**Application No:** H23-0573-24      **Applicant:** Mr M Waldowski

**Proposal:** Proposed rear single storey extension, garage conversion and internal alterations

**Location:** 4 Cobgate Close Whaplode Spalding

SITE PLAN

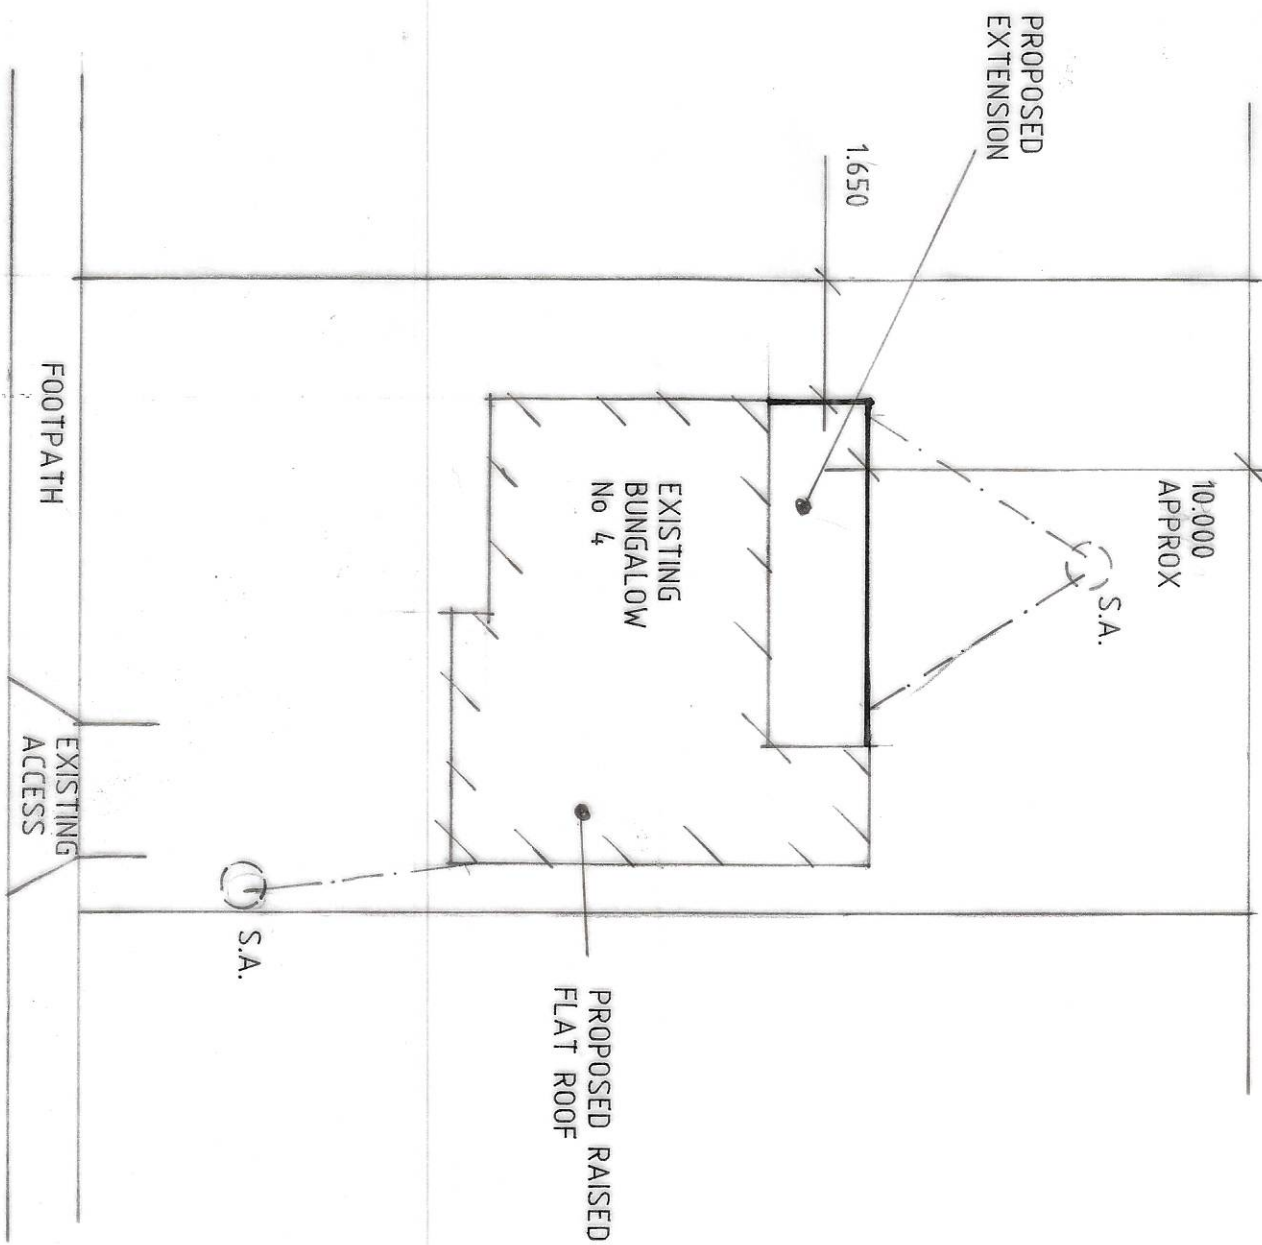
"Parking needs to be demonstrated on the proposed block plan."

To a certain extent, the alterations to the parking arrangements could be achieved via permitted development. That being said, it is considered that adequate parking space has been provided on the site in order to ensure no harmful highway impact.
